**Consultation Response from KC,
Forestry Arb Team**

2025/91870 Land off, Roslyn Avenue, Netherton, Huddersfield, HD4 7EW

Date Responded: 28 August 2025

Responding Ref: AG/2025/91870

drawing title:
Foul and Surface Water Drainage Layout Plan

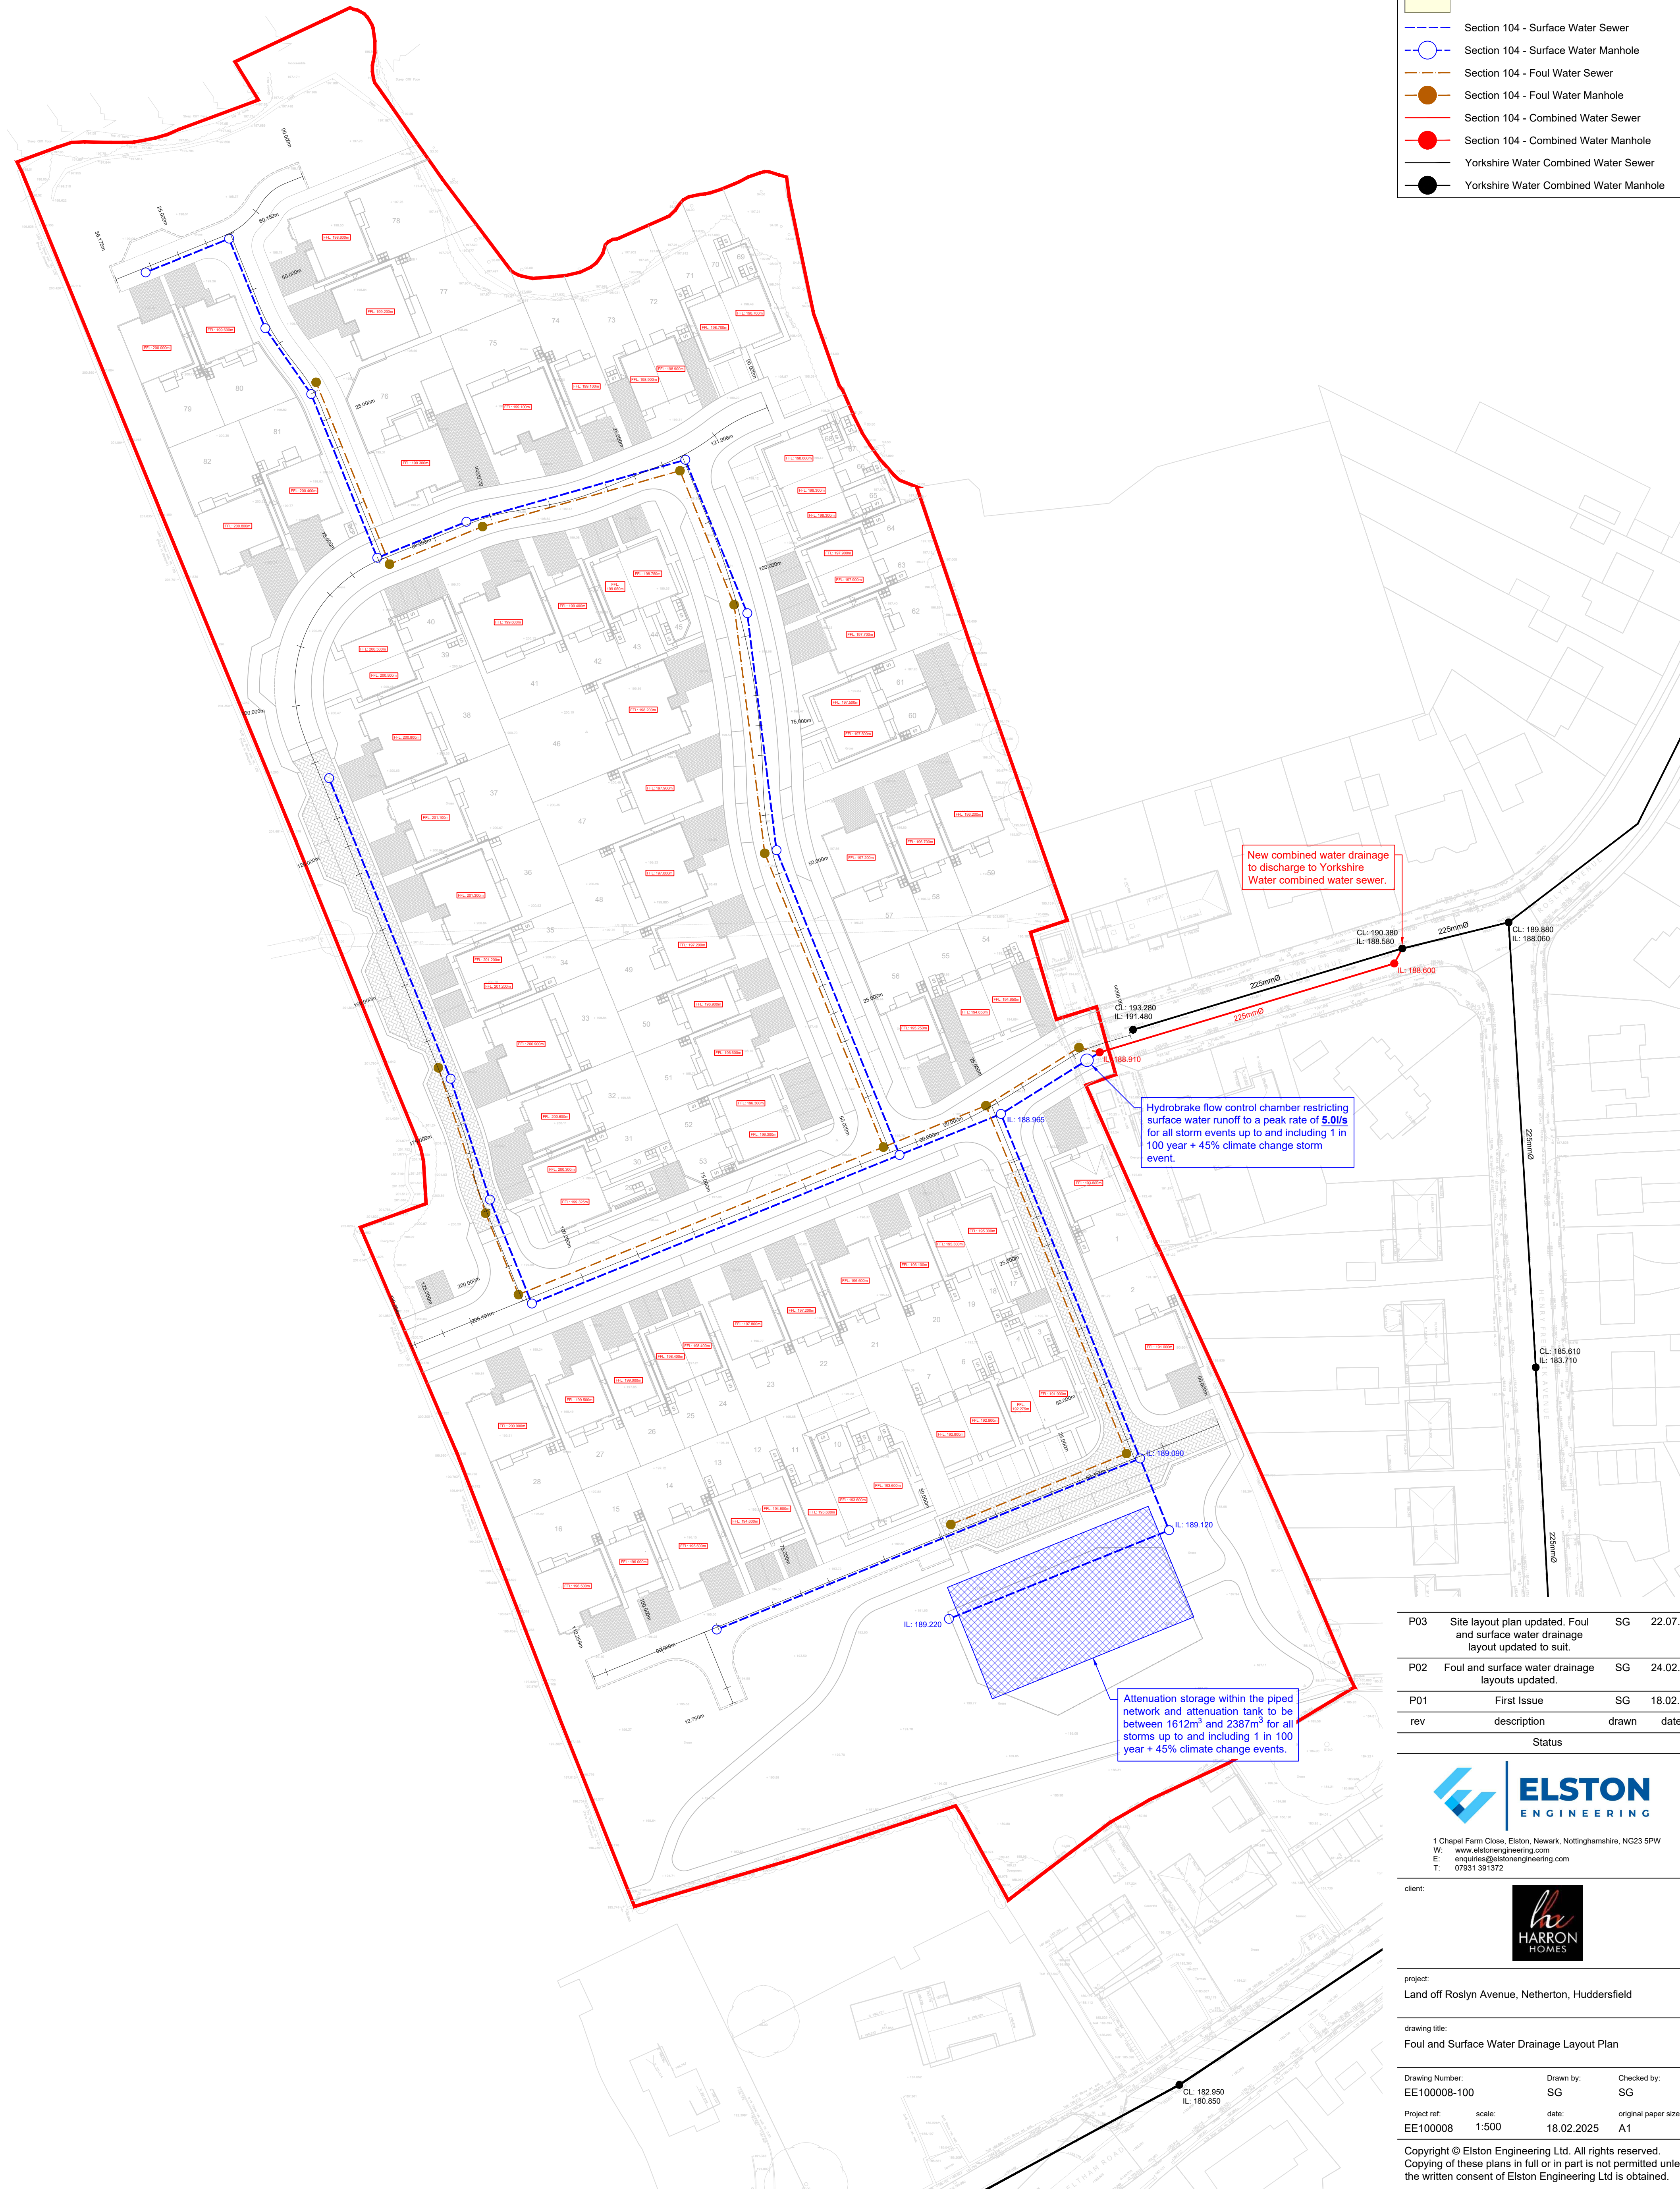
Proposed housing density along the eastern boundary of the site places properties too close to semi and early mature trees growing along the boundary of Kirklees Council owned land. It is recommended that the number of properties on this development be reduced in order to ensure suitable stand off from existing established trees along the boundary.

Foundations for properties 66, 67, 68, 69 measure as being within 7m and for property 65 within 10m of established high water demand species although submitted drawings may not be accurate for this purpose. Proposed paths and outbuildings to the rear of 65 to 68 are within 3m, in the case of 67 within 1m, of stems with future subsidence and root damage claims against the Council probable.

With the only outdoor space available to properties 66, 67 and 68 being subject to heavy canopy shading, likely damage to structures from natural canopy growth and seasonal leaf fall etc it is anticipated that further frequent requests for pruning will result in significant on going impact to these trees with associated increased risk of infection by pathogens.

It is further noted that the proposed property boundary with 32 Roslyn Avenue excludes a line of established trees within the development land parcel which, if not included in the registered boundaries of new properties, will cause friction over legal responsibilities in regard of safety maintenance.

The Arb Team understands that concerns regarding rooting zones and associated damage to the ancient woodland on the northern boundary are being addressed in detail by Planning. However, it is important to note that a minimum 15m buffer must be maintained between ancient woodland and any development.
